PROJECT NAME: MENTAL HEALTH ASSOCIATES OF MAINE, LLC

PROJECT ADDRESS: 251 WOODFORD STREET CHART/BLOCK/LOT: 123-L005-001

Administrative Authorization Decision

Name: Mental Health Associates of Maine, LLC
Address: 251 Woodford Street
Project Description: removal of pavement and replace with loam and seed

3RD REVISION 01-11-09: ADDED AREA OF PAVEMENT TO BE REMOVED & EDIT TO NOTES.
 2ND REVISION 01-25-08: CHANGED PARKING, ADDED LIGHTING PLAN AND STORMWATER PLAN.

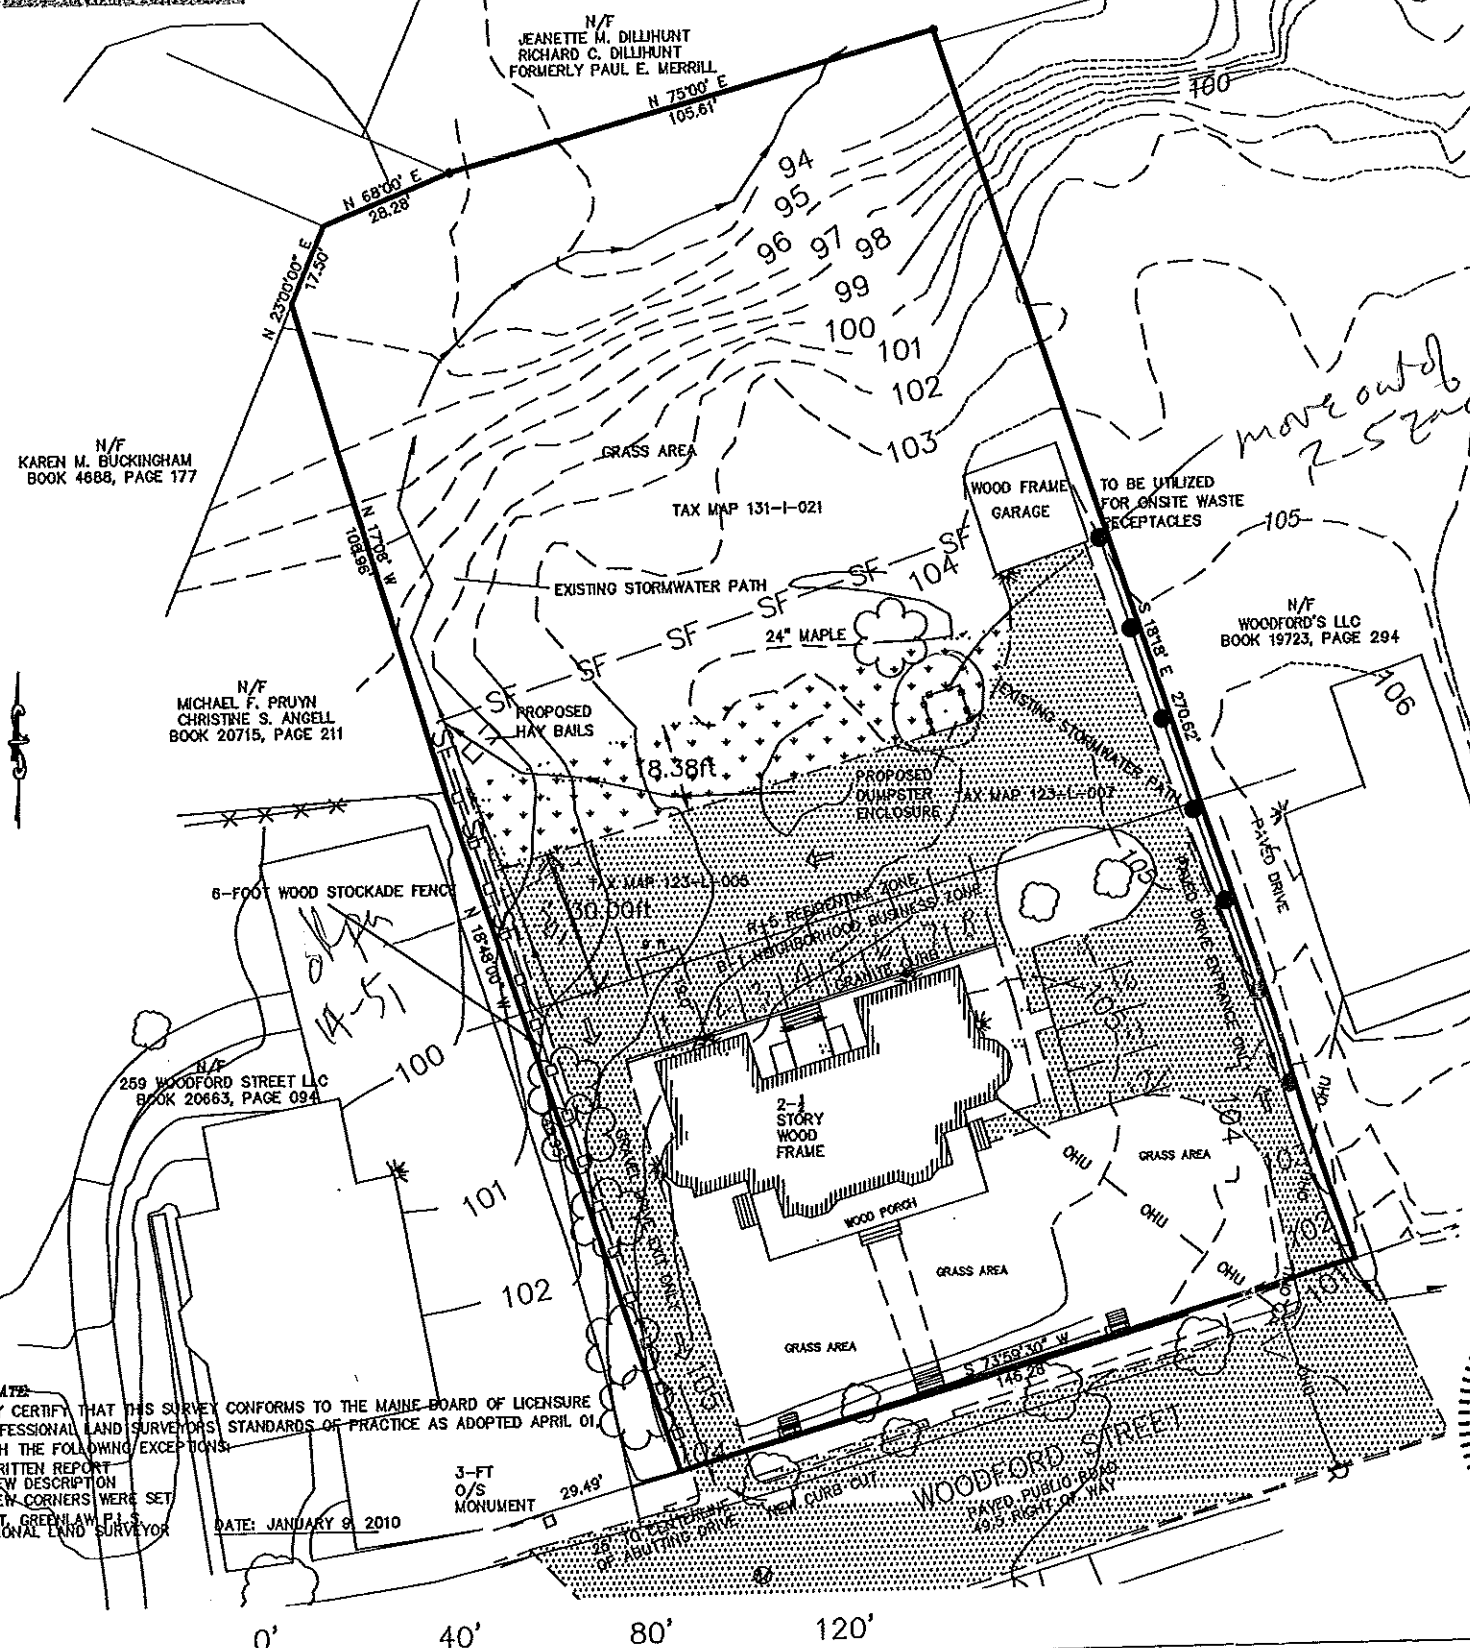
The site plan was reviewed by David Margolis-Pineo and Tom Errico at the DPS meeting on Tuesday August 28th. The plan was approved previously to mitigate the encroachment of pavement into the residential zone in order to meet zoning. The plan is acceptable with the conditions of approval stated below.

The Administrative Authorization for the removal of 18.38 feet of pavement and loamed and seeded at 251 Woodford Street was approved by Barbara Barhydt, Development Review Services Manager on August 28, 2012 with the following conditions of approval listed below:

1. The area loamed and seeded to meet zoning requirements shall not be used for parking.
2. Prior to the start of construction, a pre-construction meeting is required to confirm the pavement width to be removed and that adequate erosion control measures are in place. Please contact Phil DiPierro, Development Review Coordinator, at 874-8632 to schedule a meeting.
